Application no: H23-0710-11

Description: Details of new garage, tree planting and archaeology report (Conditions 5, 6 and 7 of H23-0270-09)

Location: 107 Broadgate
Whaplode Drove
Spalding
Lincs
PE12 0TW
PE12 0TW

Amendment: Revised landscaping details (dwg. no. WEN/1449/11/00A)

DRAWING N°:
WEN/1449/11/00 A

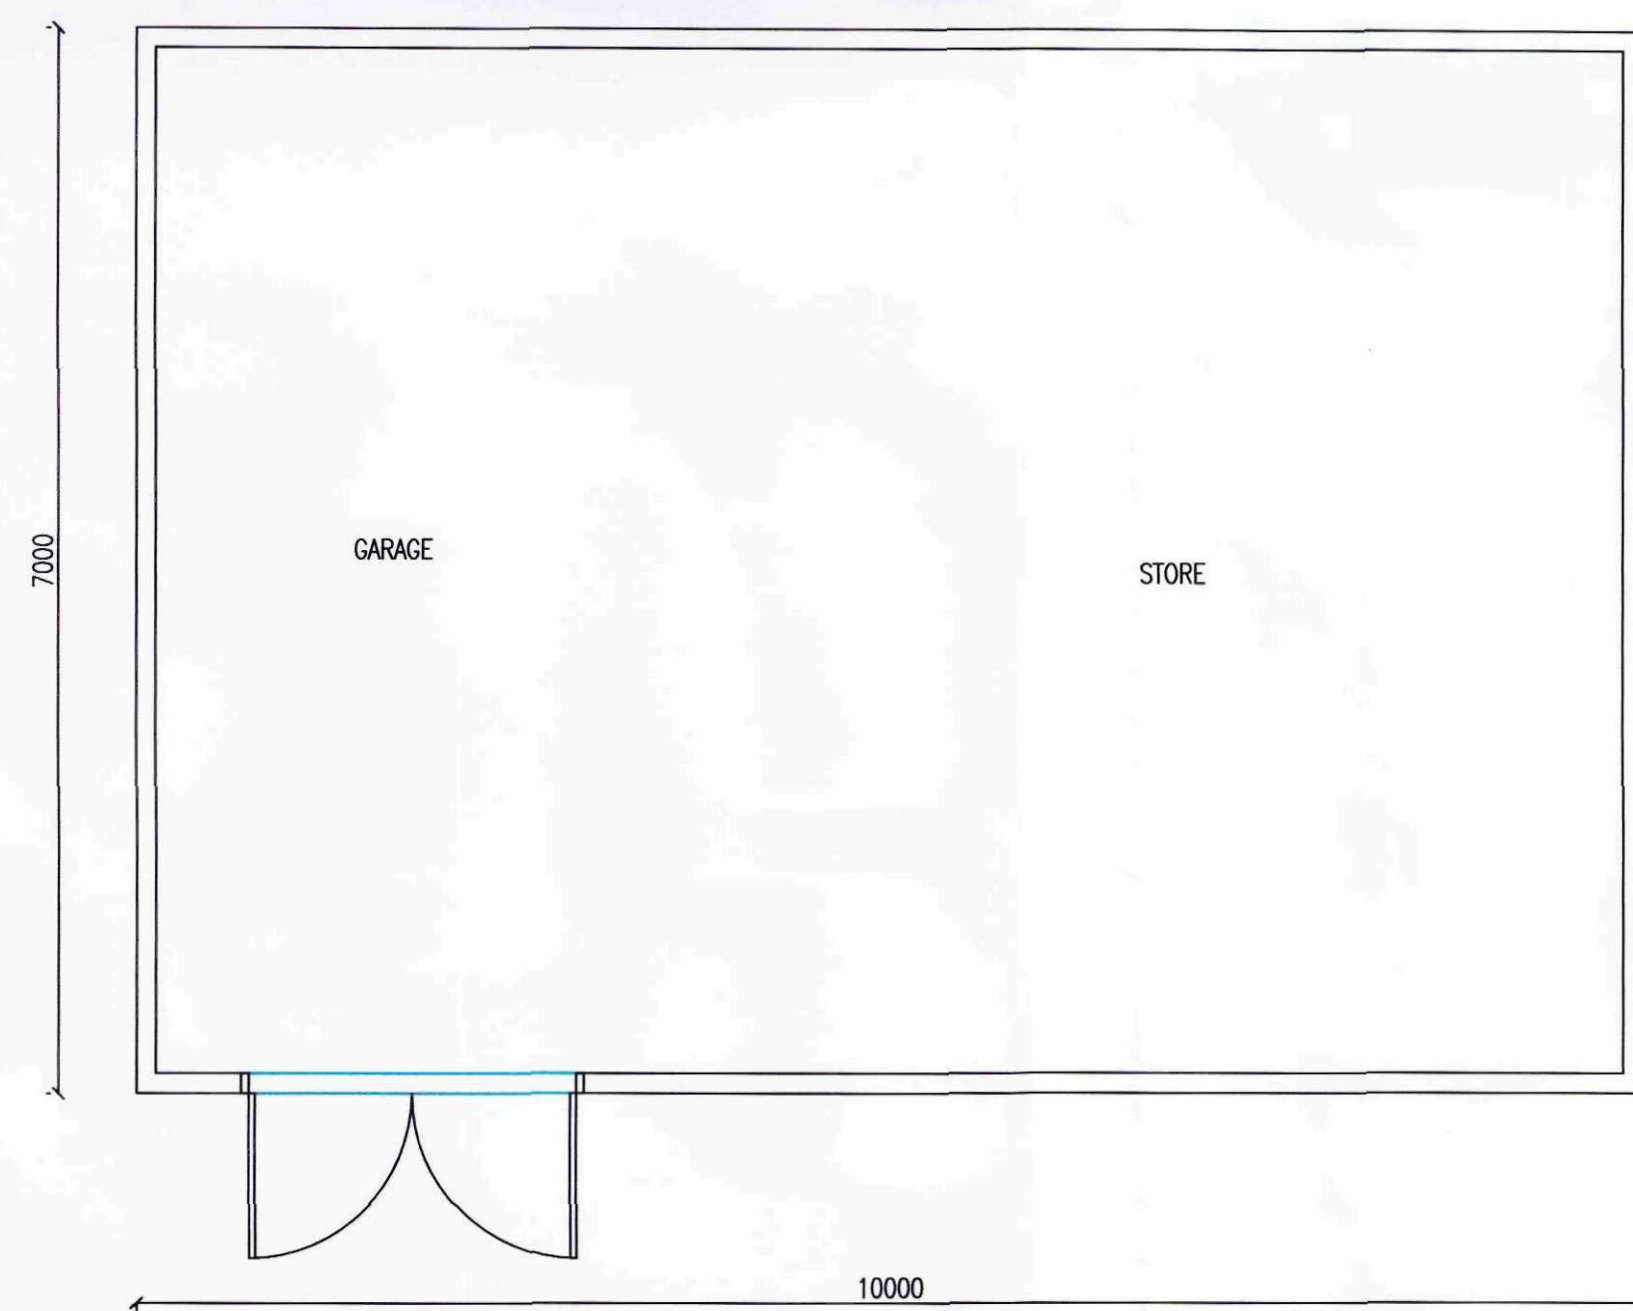
Unfortunately, the landscaping scheme submitted is not satisfactory and needs to include tree planting along the site's frontage, as opposed to low level shrubs.

Further to speaking to Mrs Fines yesterday she has asked that I include 4 trees on the frontage of the property. I attach herewith an amended plan showing the trees. The trees will be set back 2m from the road so that they do not obstruct visibility for vehicles leaving the site.
